Date: 23 March 2018
Your Ref: A/11/OUT and A/23/15/OUT
Our Ref: 9349

OBJECTION TO APPLICATIONS A/11/17/OUT AND A/23/15/OUT RELATING TO LAND SOUTH OF NEW ROAD (A259) AND EAST OF BROOK LANE ANGMERING

Closure of Brook Lane Access (pertinent to A/11/17/OUT only)

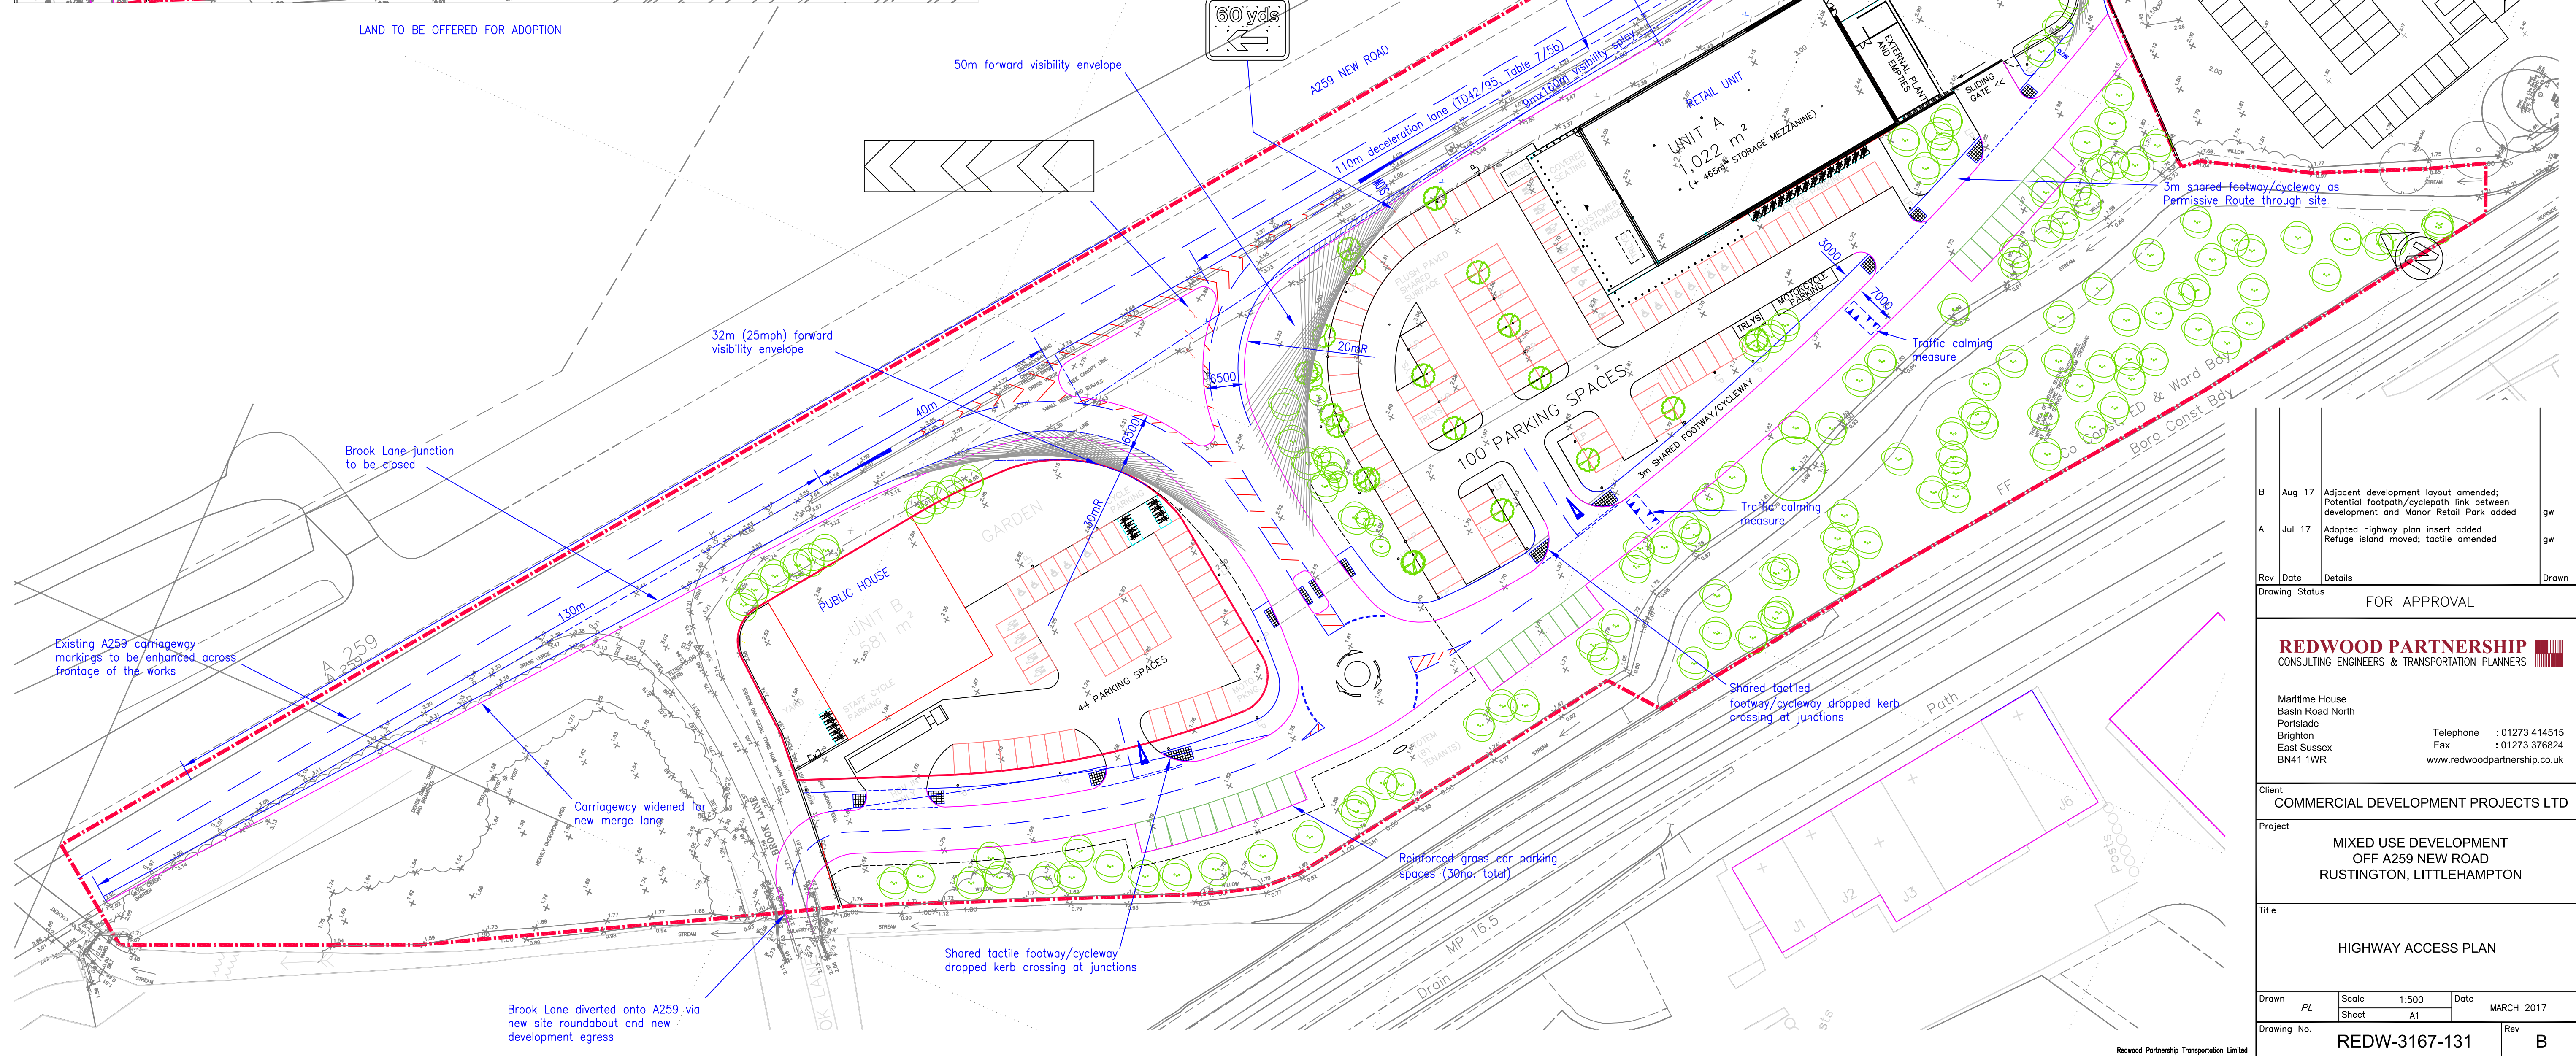
The advice from WSCC is that they would not adopt the internal roads. SDB's access plan (REDW-3167-131B) therefore needs to be updated as it currently states that the routes would be 'offered for adoption'. Either the scheme needs to change prior to determination to ensure that adoption is a realistic probability, or the applicants should ensure that the implications of their design are properly understood. In particular, we consider that the access proposed would not be suitable for the residential scheme which is a committed development. A residential scheme of the size proposed on my client's site would need a road built to the boundary which was at the very least built to adoptable standards. If the road is not going to be adopted, this is likely to reduce the attractiveness of the site to residential developers and therefore threaten the delivery of new homes which would make a valuable contribution to the Council's housing land supply.
